From: [Nick Wright](#)
To: [Martina Mackin](#)
Subject: Re: -21/00101/FUL
Date: 21 February 2021 15:41:30
Attachments: [PA 005 Proposed Elevations Rev A.pdf](#)
[PA 006 Existing and Proposed Roof Plans Rev A.pdf](#)
[PA 003 Existing Elevations Rev A.pdf](#)
[PA 004 Proposed Ground and First Floors Rev A.pdf](#)
[PA 002 Existing Ground and First Floors Rev A.pdf](#)
[PA 001 Location and Site Plans Rev A.pdf](#)

In response to your letter dated 19th February 2021 I attach revised drawing set to address the matters that have been raised.

Drawing No. PA 001 Rev A

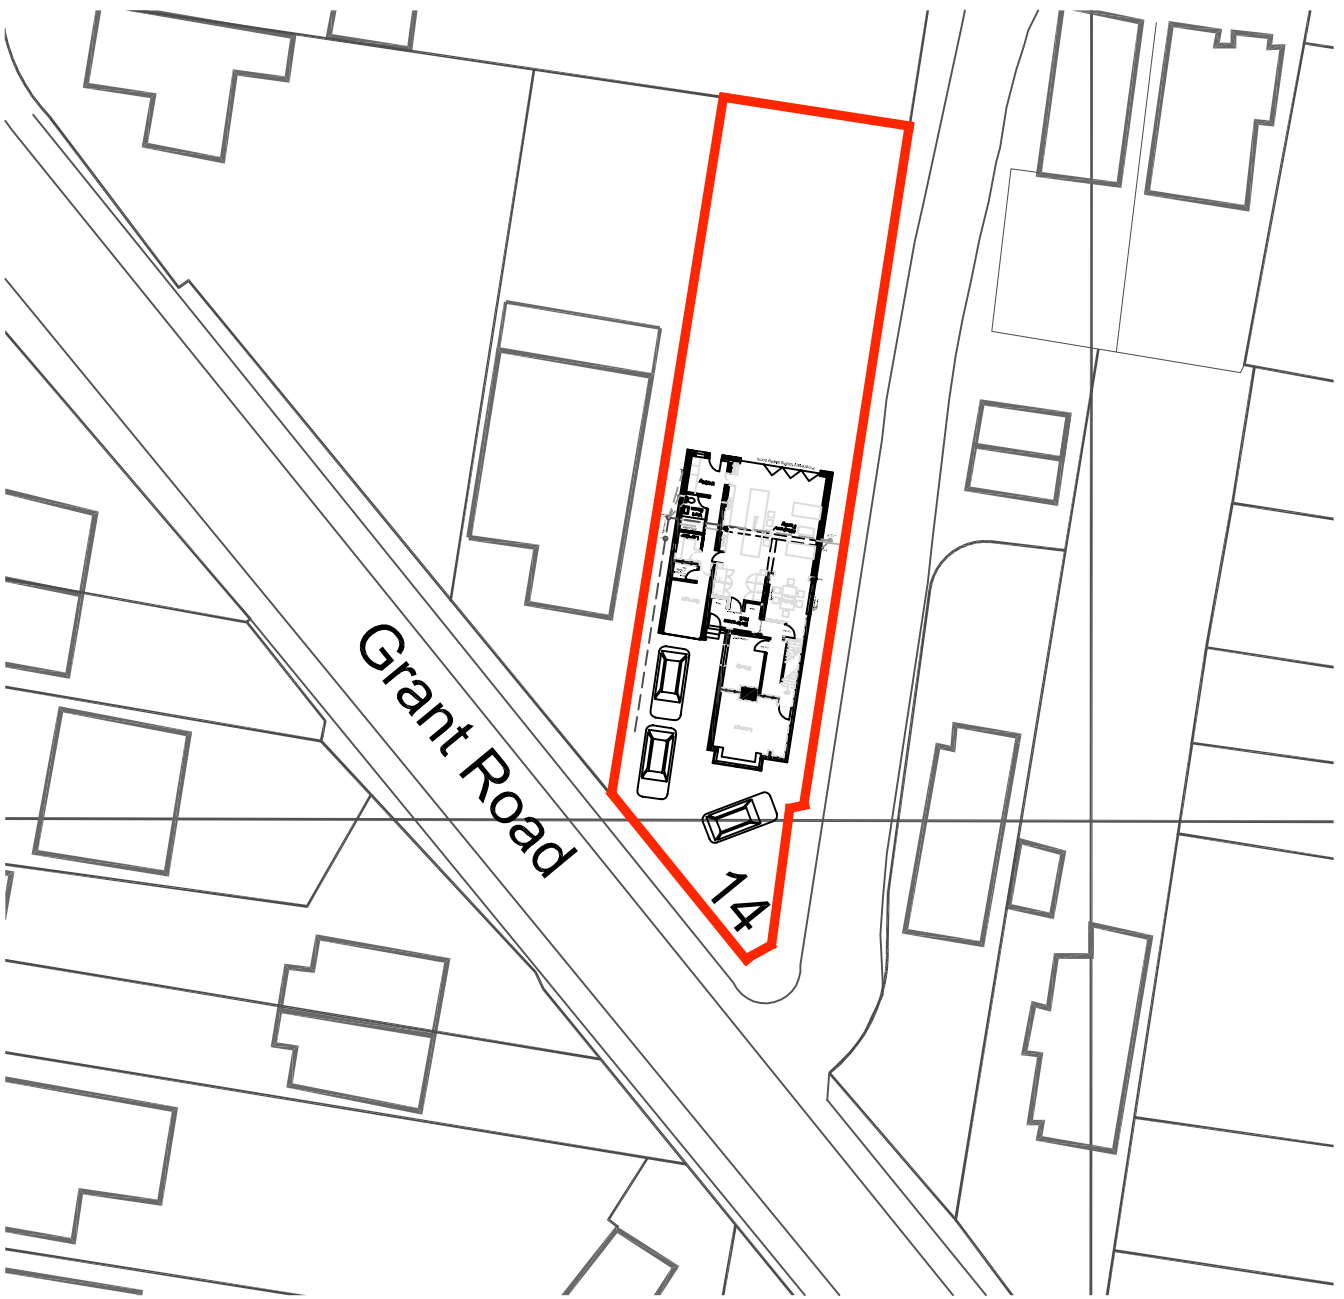
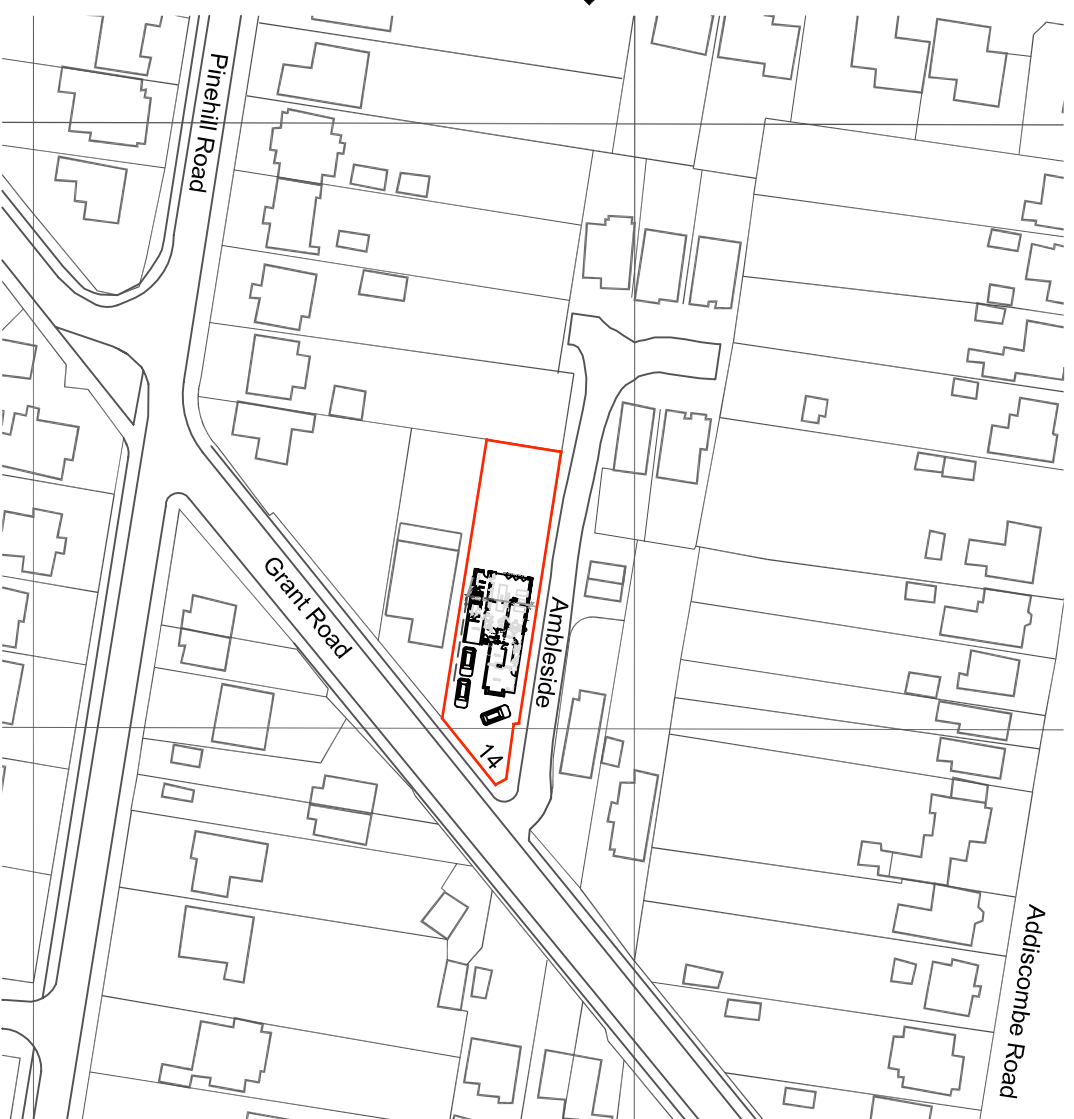
- 1 The fenestration on the South and North elevations has been corrected.
- 2 The Location and Site plans now show the proposed development.
- 3 Both the rooflight and lantern on the single storey rear extension are visible from the sides.
- 4 Parking for a minimum of 3 no. estate cars has been indicated, to scale, on the Location and Site plans.
- 5 The East elevation has been added to the drawings to show that no part of the proposed extension will be visible from the front. The drawings have been revised to more clearly show the parapet screening the roof.
